From: Sue Howell
Sent: 04 March 2019 16:07
To: Planning.Responses
Cc: Andrew Wood; Mark Warwick
Subject: RE: Planning Consultation on FG/4/19/DOC

NOTIFICATION FROM ARUN DISTRICT COUNCIL
TOWN AND COUNTRY PLANNING ACT 1990
APPLICATION FG/4/19/DOC

Site Address: Garage Premises Littlehampton Road Ferring BN12 6PB

Description of Works: Approval of details reserved by condition imposed under ref FG/39/18/PL relating to Condition No 7 hard & soft landscaping and Condition No 11 control of car transporters & deliveries.

Drawn by	Checked by	Date
MJ	KC	OCT 18
Drawing Name		
17036-HNW-00-XX-DR-A-W121		
HNW Architects Ltd - Registered No. 3589904

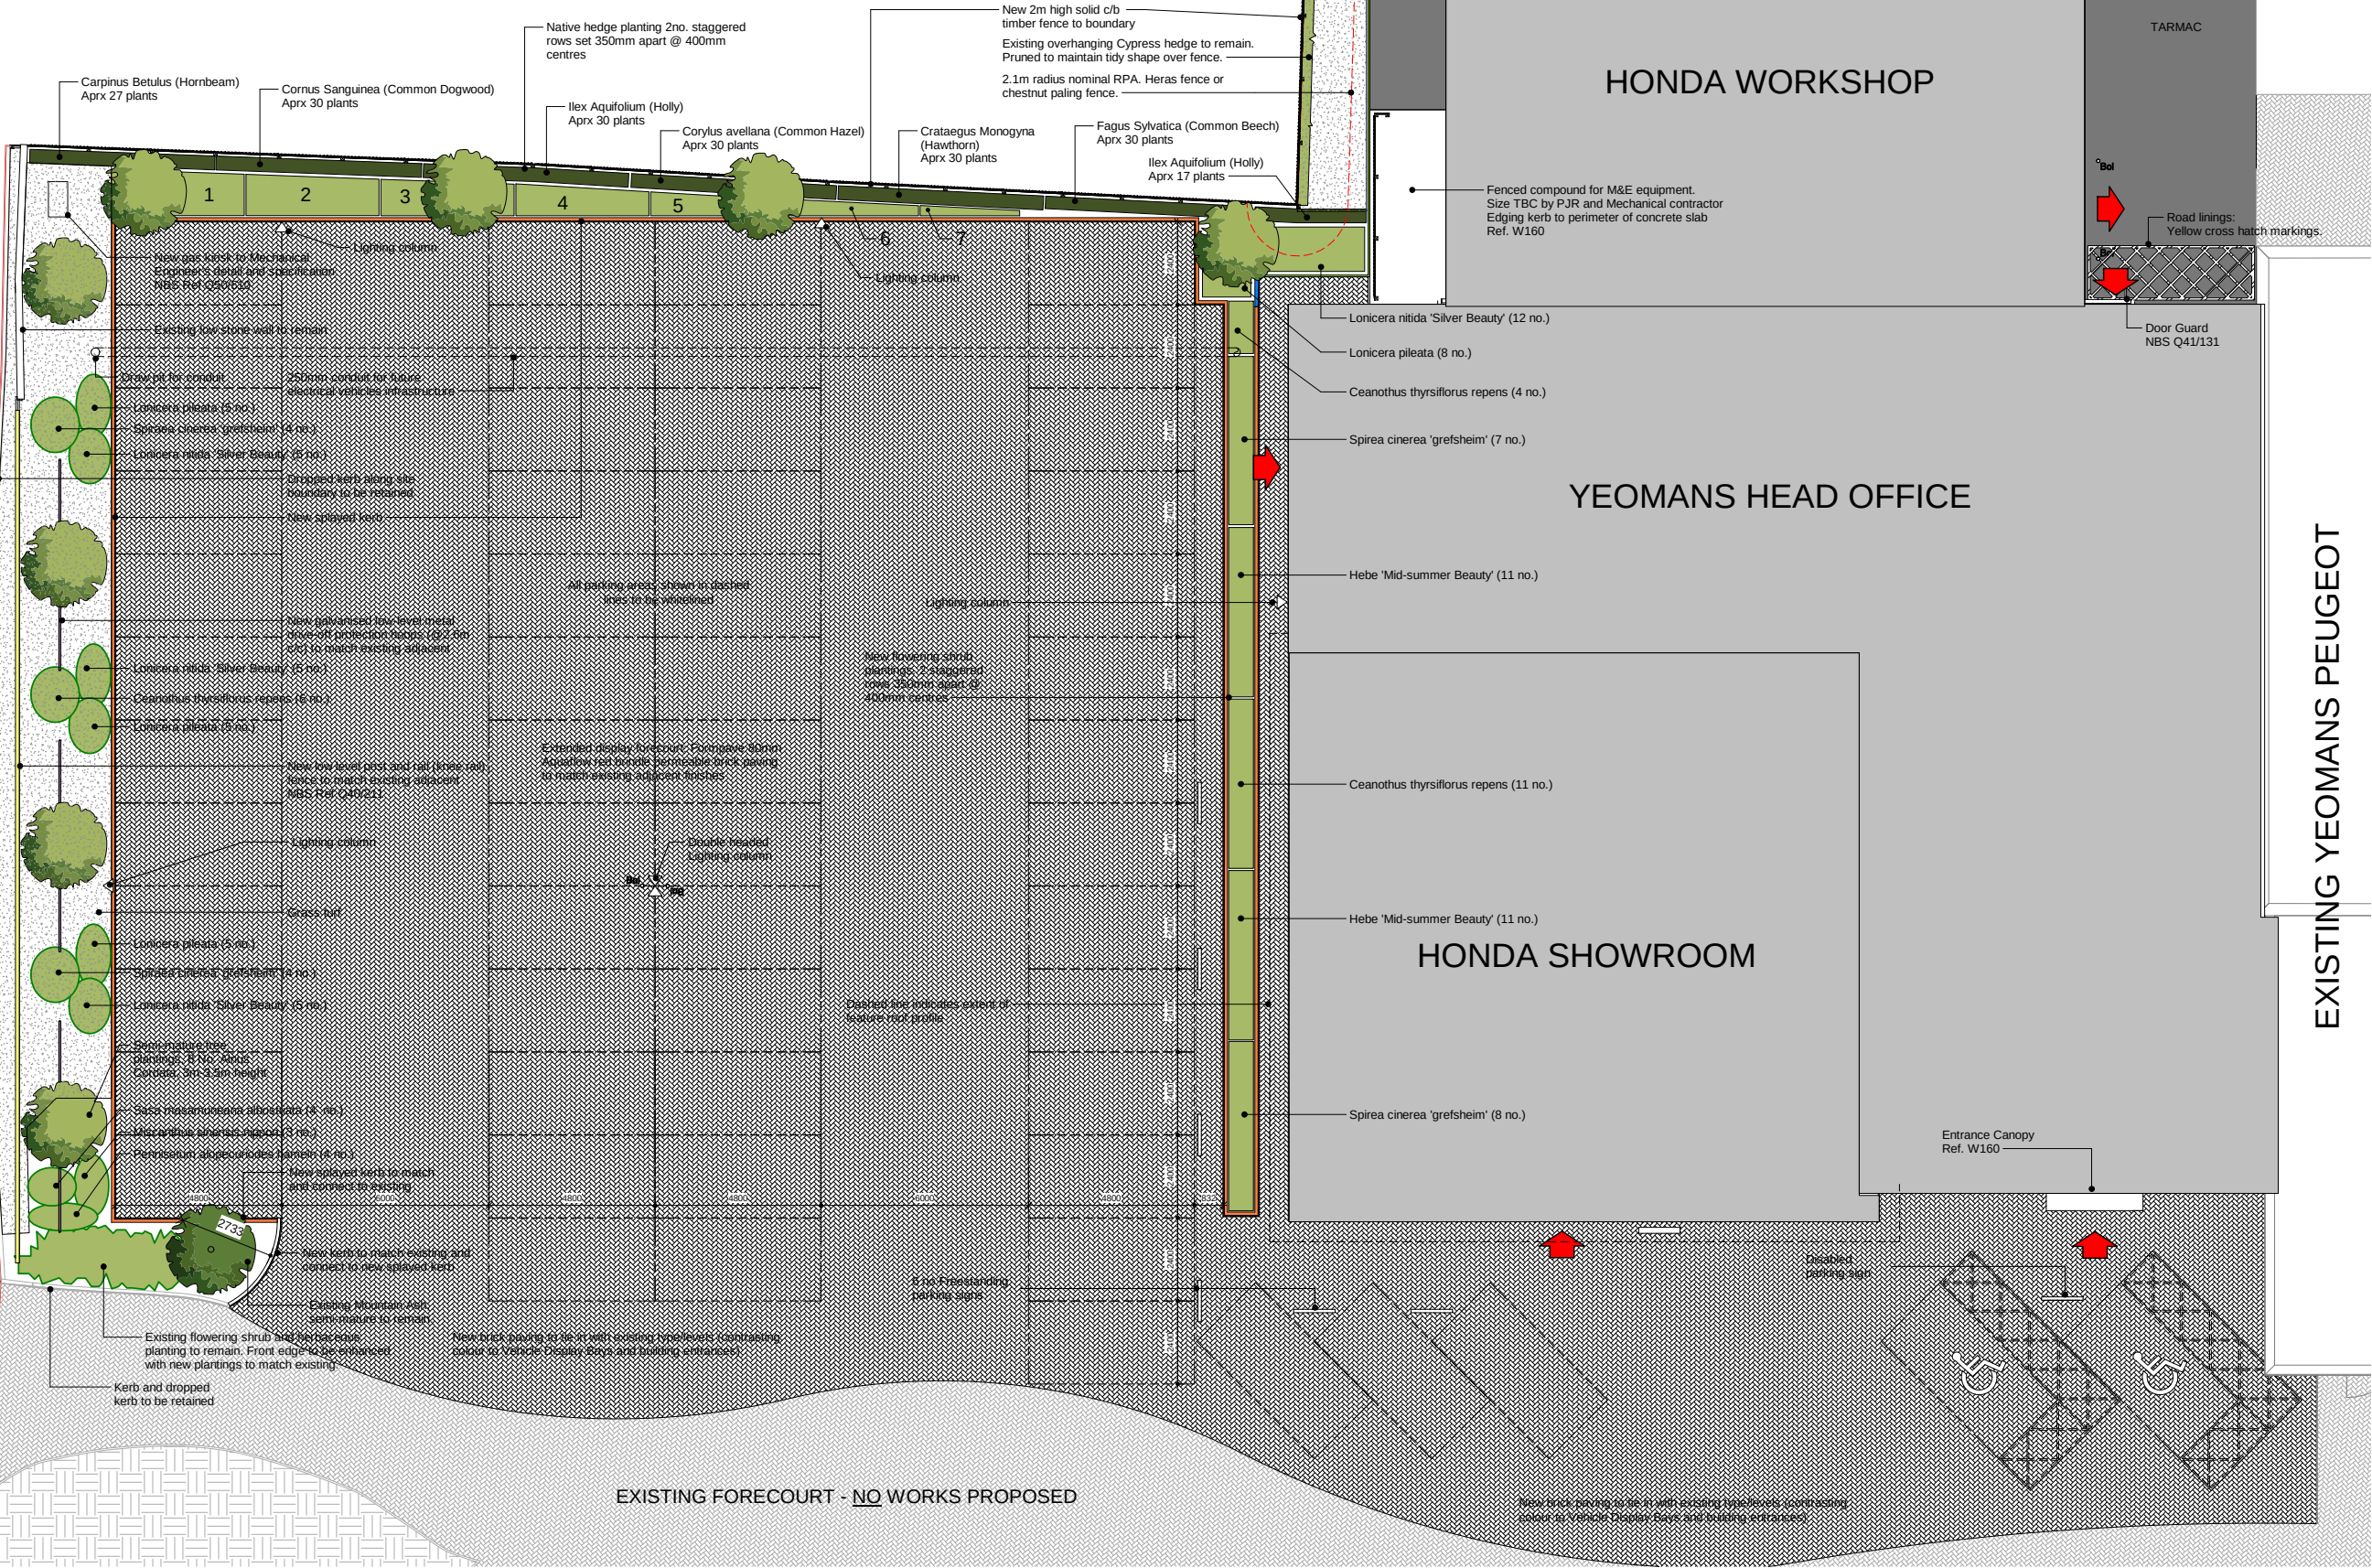
I would query however that the new tree planting to the Western /Hangleton Lane and Northern Boundary are detailed as Semi-Mature stock to match existing, however these are shown on plan and schedule as 10-12cm girth 3-3.5m size tree which are not Semi Mature trees but Select Standards.

Please amend plan/schedule so as to avoid doubt to show Semi Mature stock at 18-20cm+ 4.0-4.5m tall.
